**OXFORDSHIRE COUNTY COUNCIL'S RESPONSE TO CONSULTATION ON THE
FOLLOWING DEVELOPMENT PROPOSAL**

Application no: 14/02156/OUT

Proposal: Outline application for up to 95 no. new homes

Location: Land South of Cotefield Business Park, Oxford Road, Bodicote

Figure 22: Potential Footpath Network Improvements

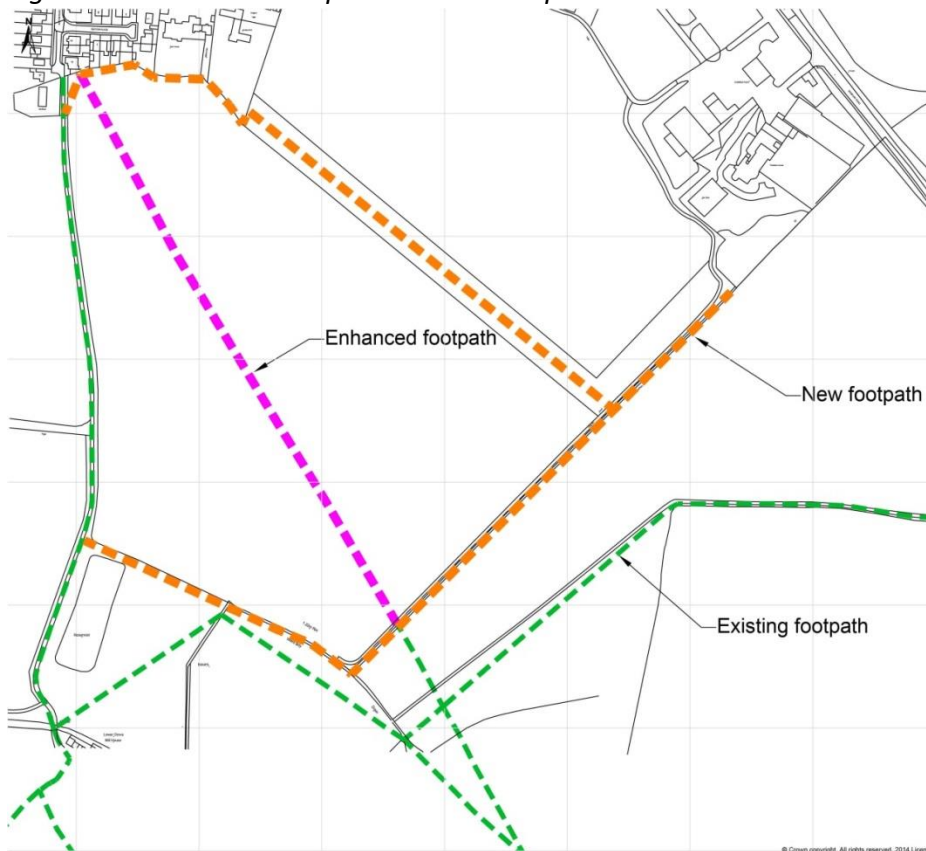
The proposals mention that the existing footpath (Bodicote Footpath 6) that runs across the field (and is marked on the plan) will be enhanced; however I can't find any information on how this will be enhanced.

Plan 7993-0060-01 shows the most southerly proposed path (running from Bodicote bridleway 4 in a south-easterly direction and then turning to run in a north-easterly direction up to the development) as being located to the south of the boundary. I would question whether this route should be shown to the north of this boundary where this appears to be provided on the ground at the moment?
